Your Ref: OWPC21393
Our Ref: EP/186/18/HH 21-12-2018
Please ask for:
Zac Denton

Two storey side extension, rear extension and front extension including demolition of existing conservatory and alterations to fenestration

1 Tamarisk Way East Preston

DRAWING TITLE
Proposed Second Floor Plan &
Elevations
PLANNING ISSUE

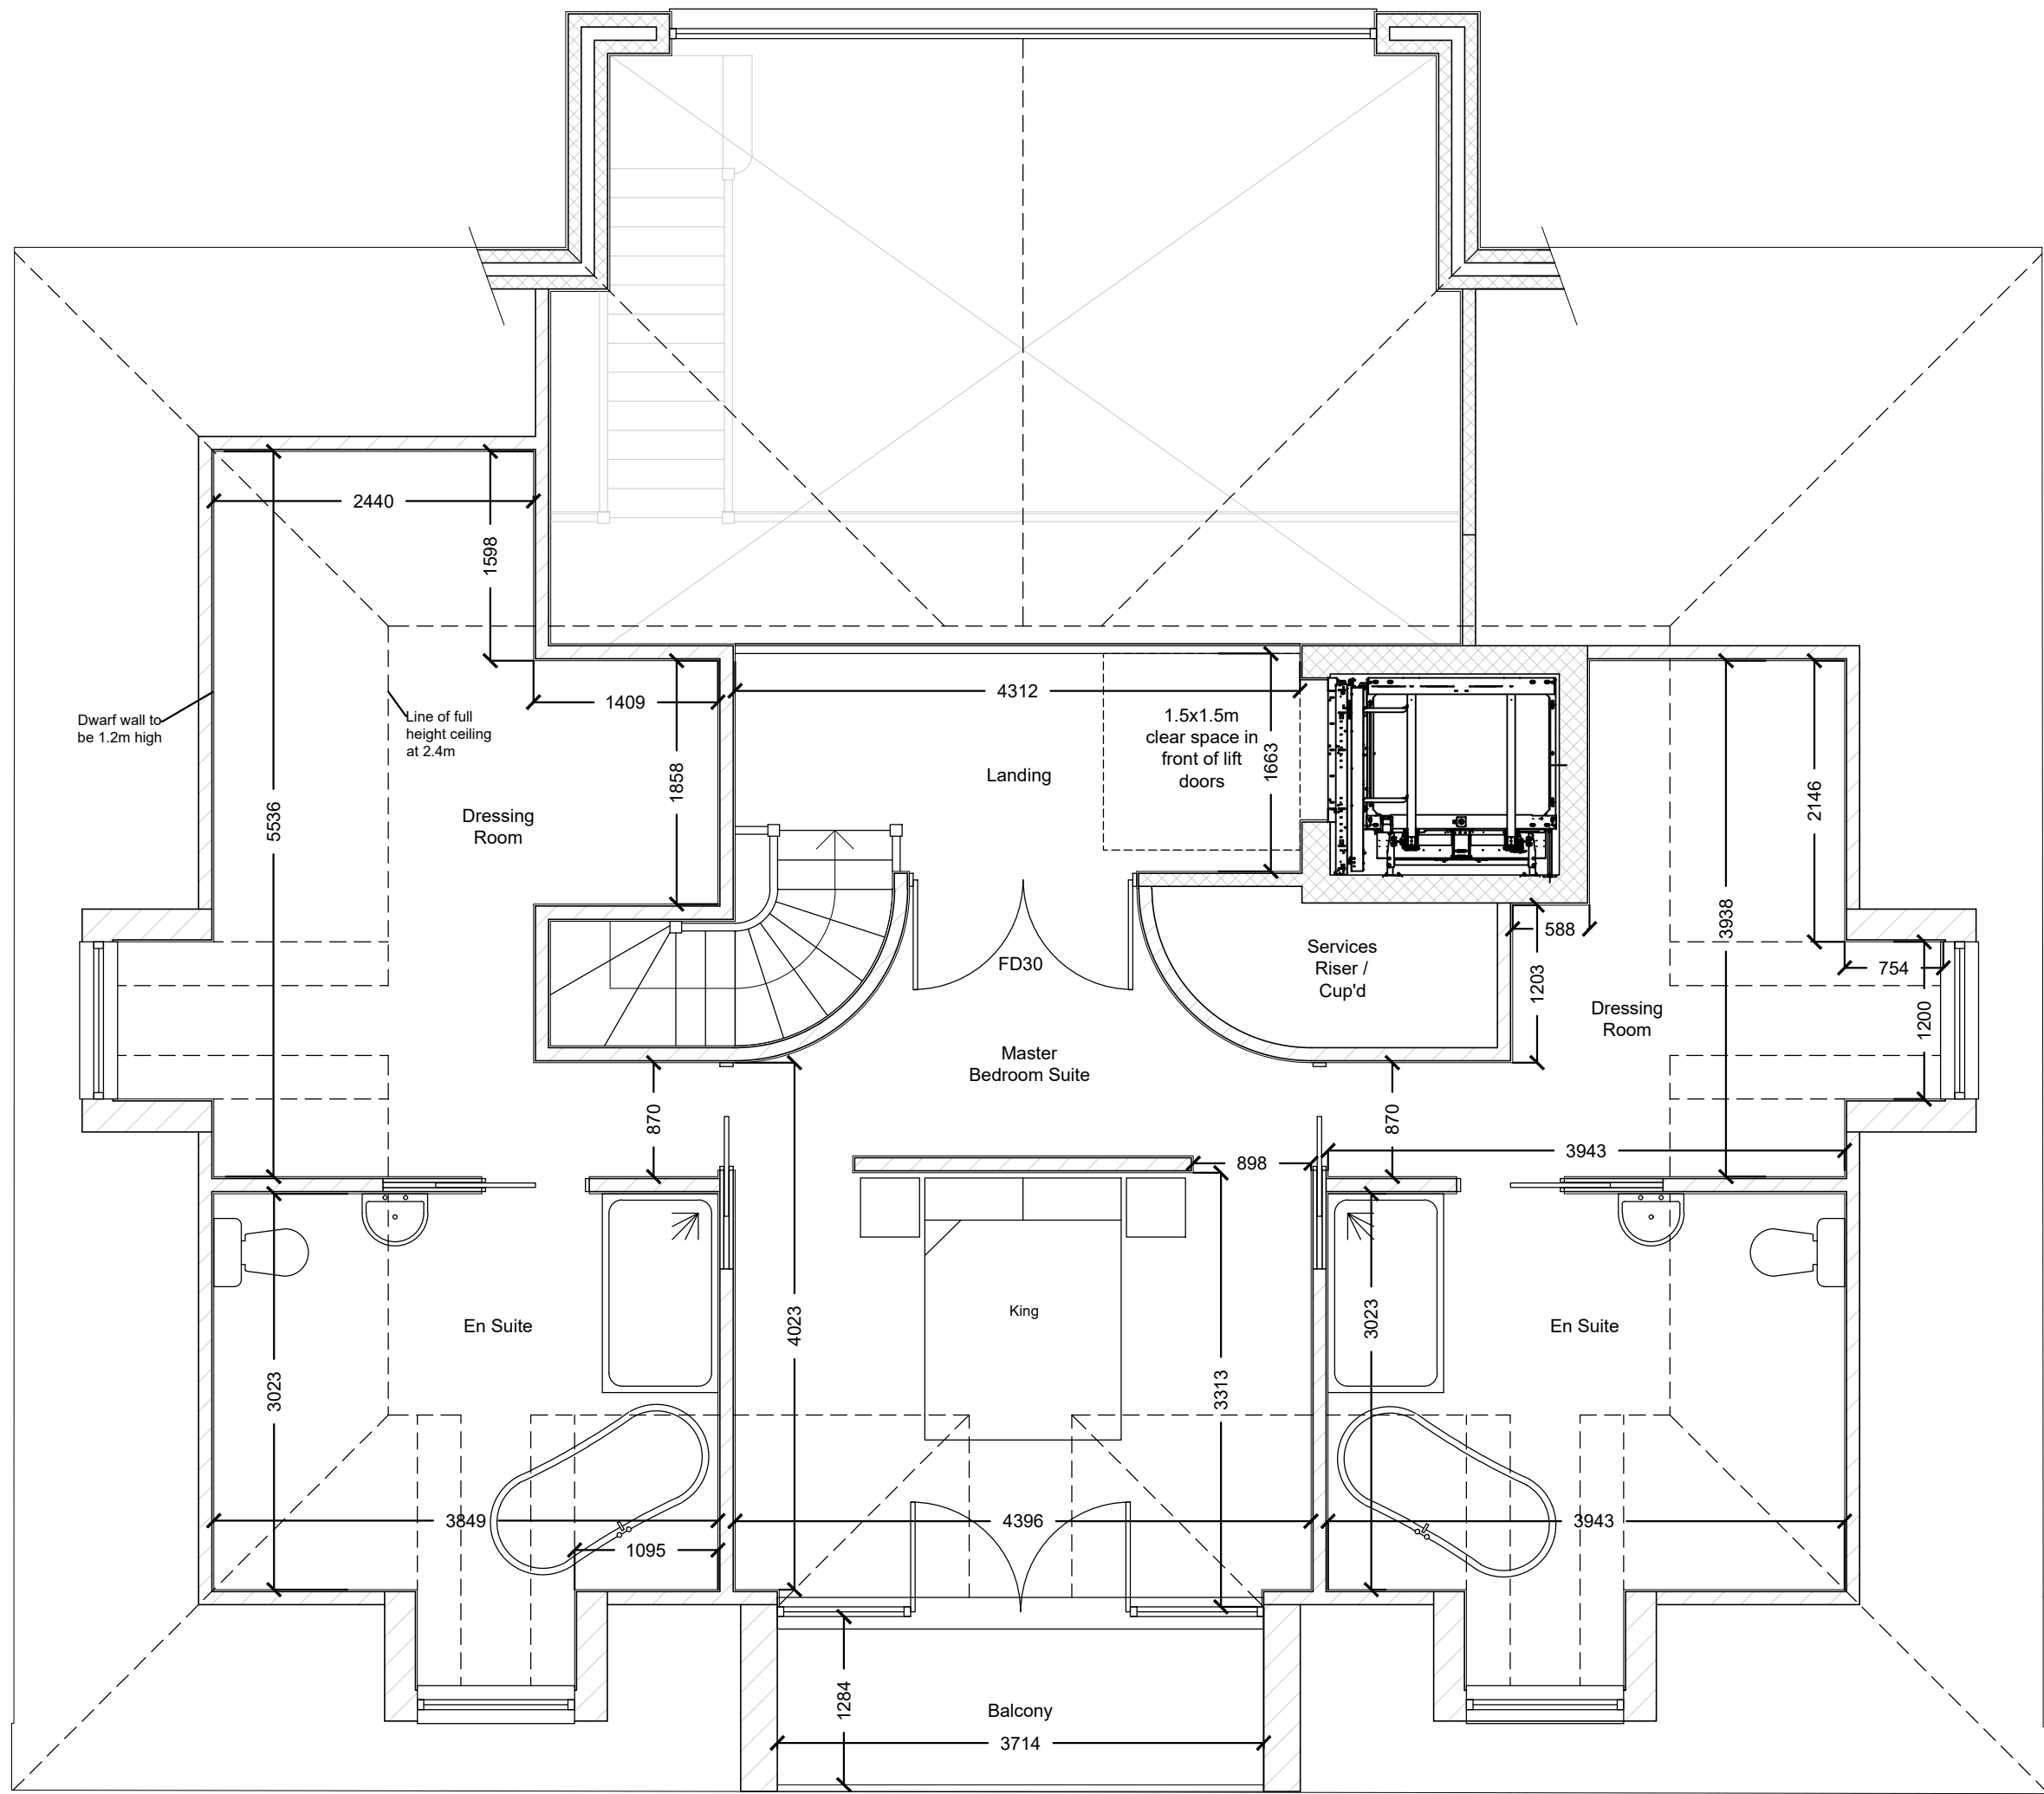
1) we have 2 windows on our East side which are approx. 2 metres from the new garage/swimming pool 2 storey (West) side extension proposed by No 1. These have been in situ, albeit replaced in our rebuild in 2013, since mid 1990's when this "annexe" was built and we want to be sure that we will not lose light as a result of this side extension at No 1. These windows are on the South end of our annexe, opposite the swimming pool part and this looks to only have roof lights/windows at this southern end, not a full storey so there should be no impact but we would like confirmation.

2) the plans include a south-facing 2nd floor balcony in the middle of the main house. We were told not to apply for a 2nd floor balcony as it would be refused by ADC as it has been with other properties along Tamarisk Way. Presumably this will be refused also.

Proposed Site Plan 1:200

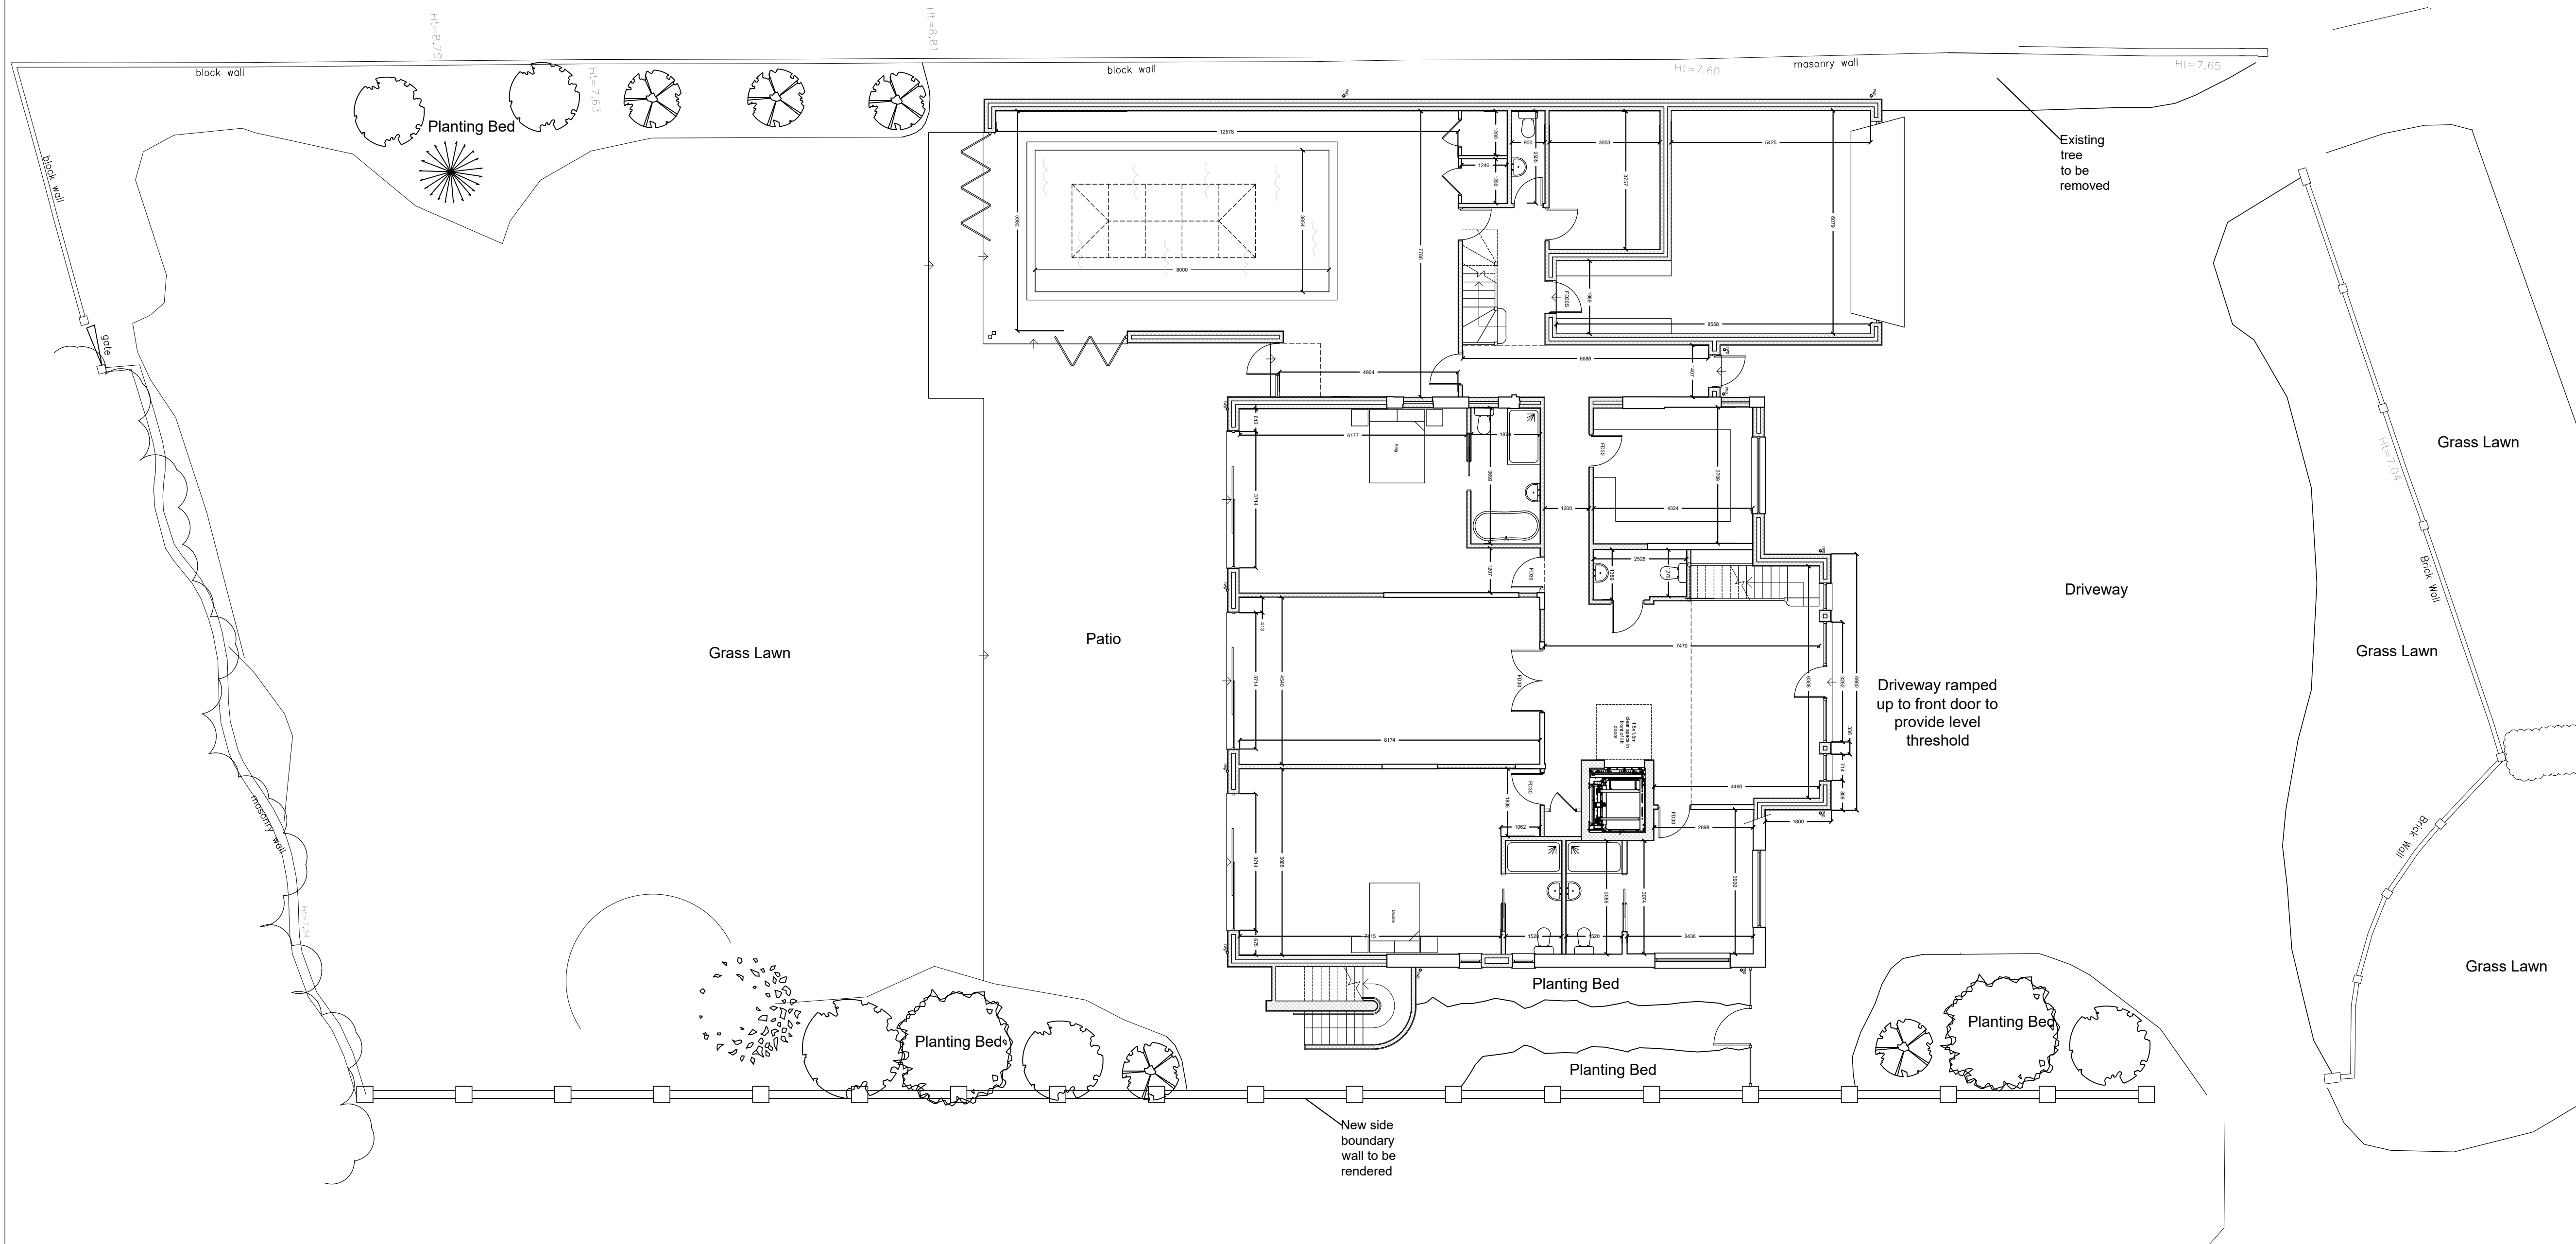
We would mention that the plans for our house do not show our East side annexe extension which has been in place for almost 25 years as mentioned above. Hence, a proper current alignment of building lines cannot be made when viewing all these plans. Finally, and this is a comment to ADC, not on these plans, but we did not receive ANY notification from ADC that a planning application had been submitted by our neighbours and know that this always used to happen so don't understand why it did not for this major project. We were formally notified on Monday 4th February by Willowhayne Residents Association to whom a planning request has also been made.
We look forward to seeing the completed project - but not to the noise and mess in the process!! Thank you to respond to our comments
